Our Ref: EN010135

Planning Act 2008 (as amended) – Section 51

Application by EPL 001 Limited for an Order Granting Development Consent for the Stone Street Green Solar

Advice following issue of decision to accept the application for examination

Drawing Title:
Illustrative Layout Plan
Sheet 3 of 5

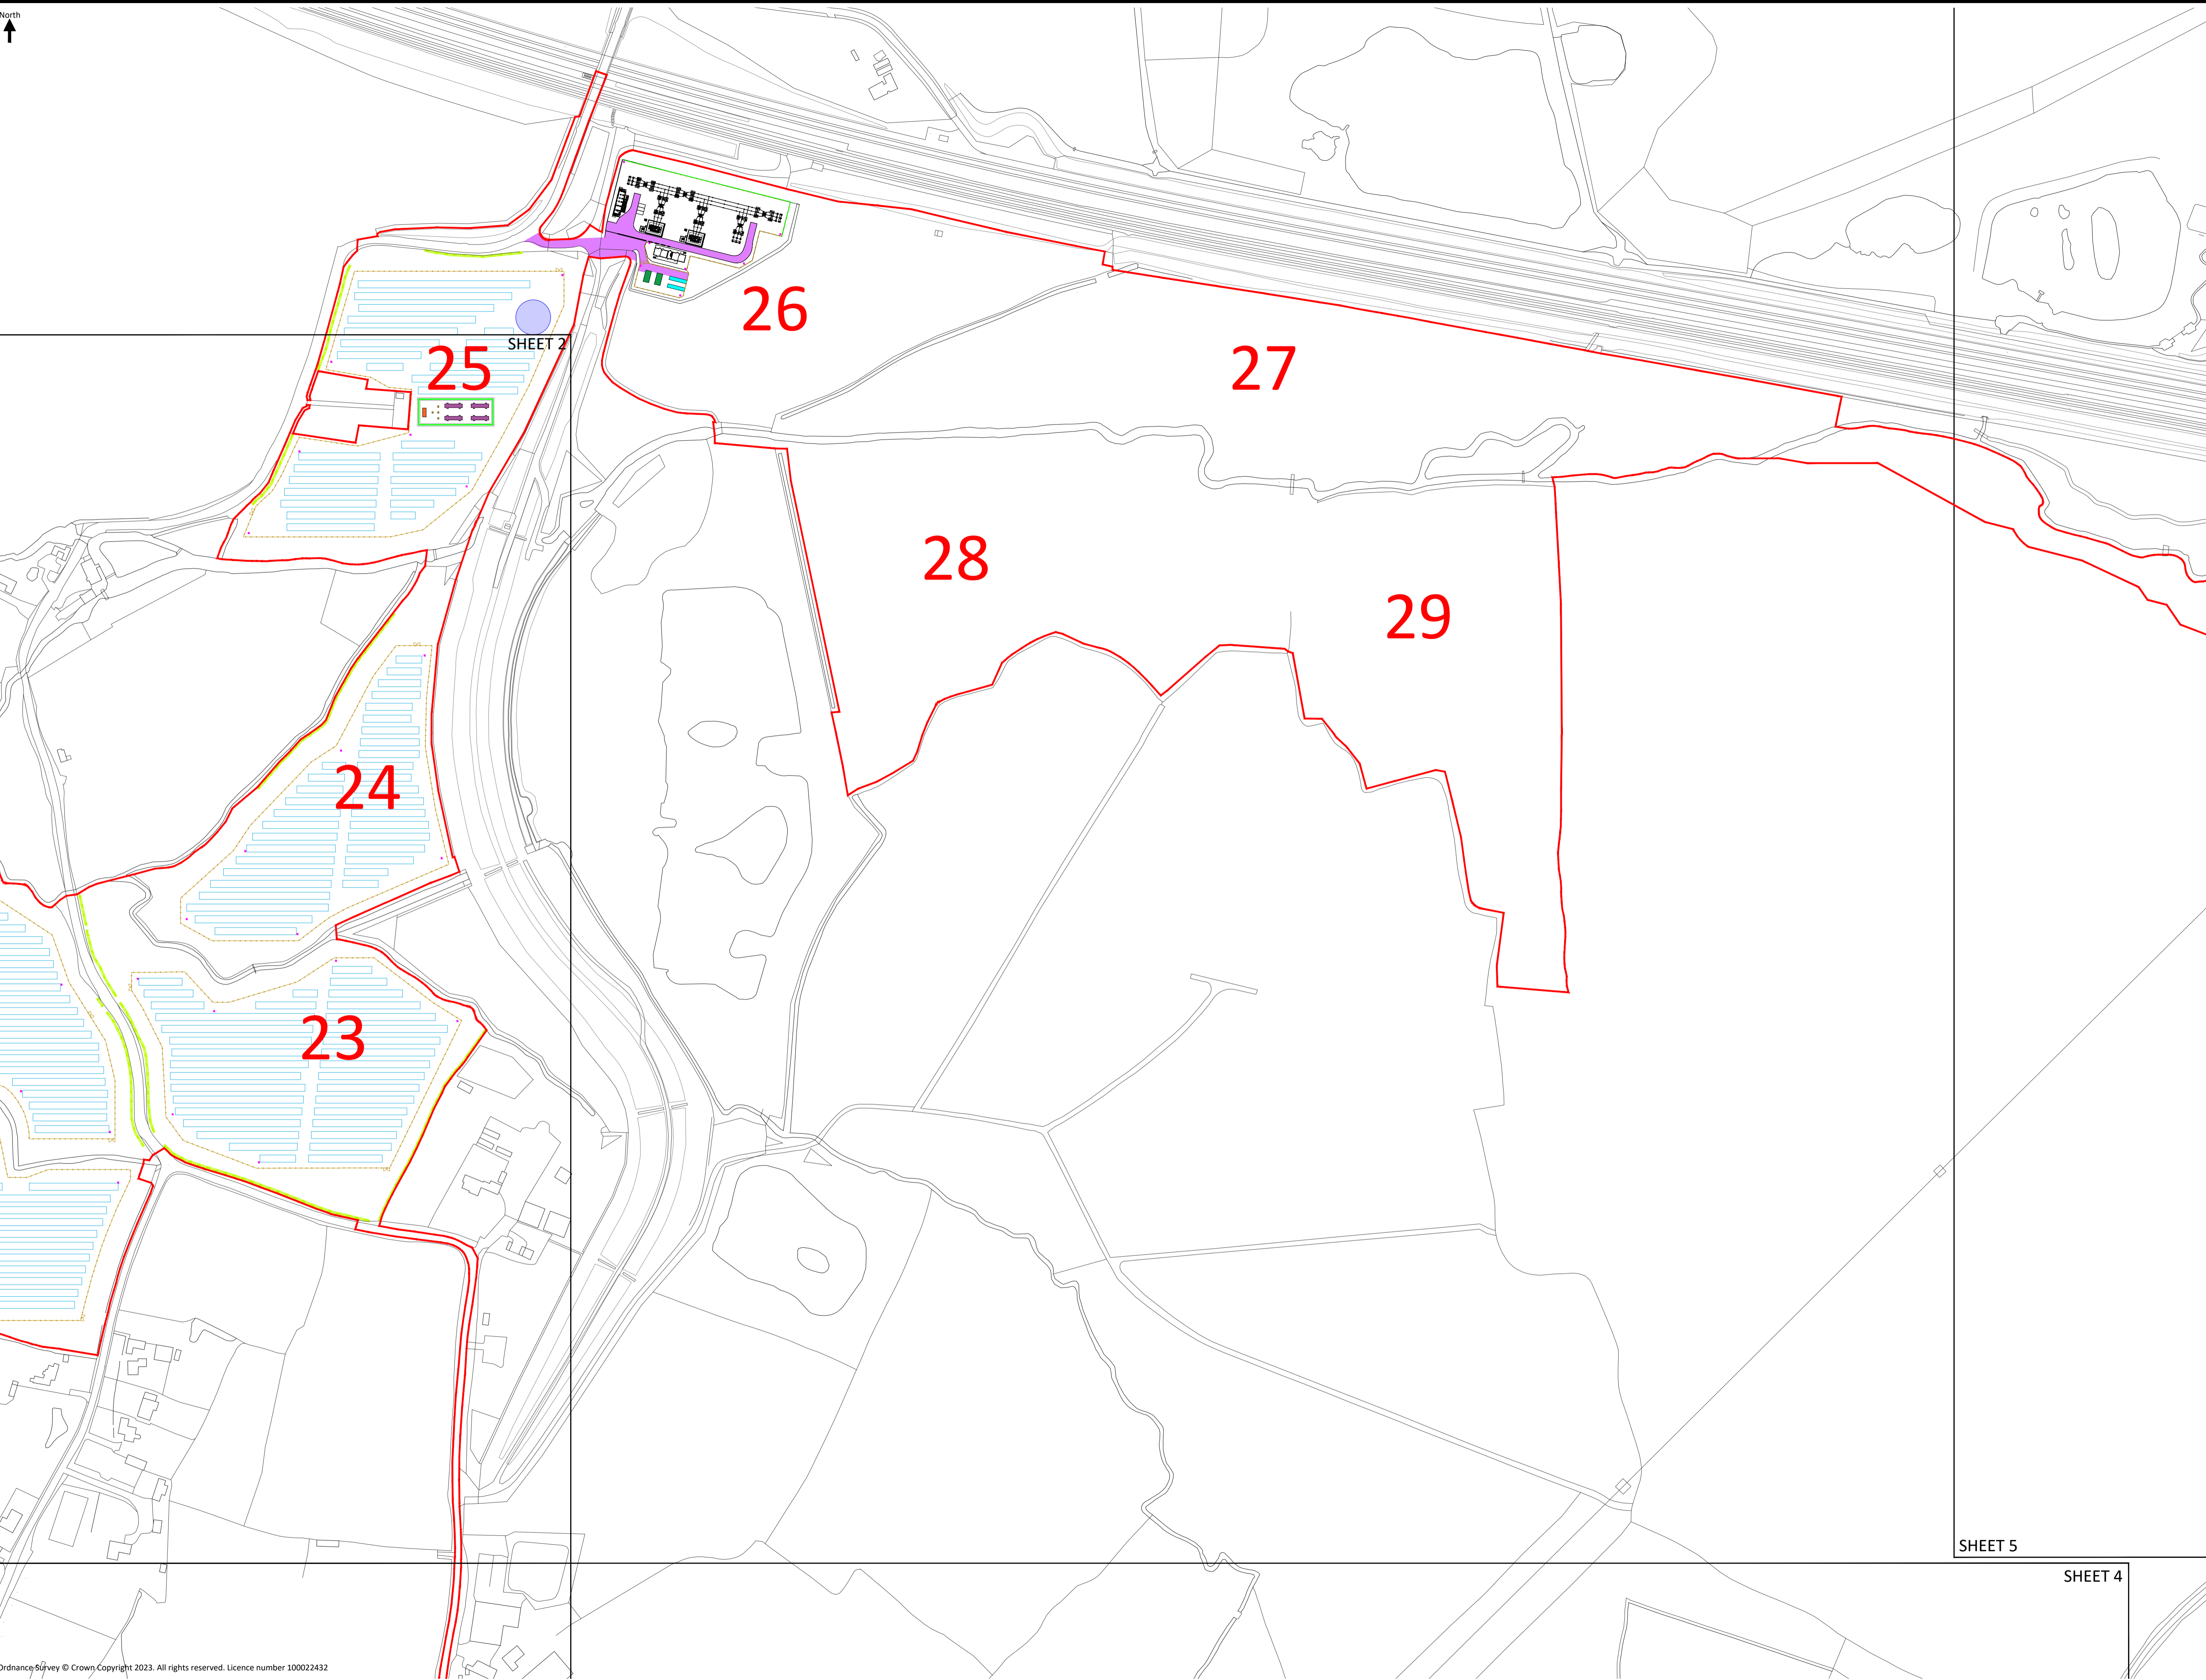
Please can the Applicant clarify what area would be enclosed by the Stock Fence in Field 29 relating to the Illustrative Project Drawings not for approval Sheet 3 of 5 Illustrative Layout Plan **(Doc 2.6)**.
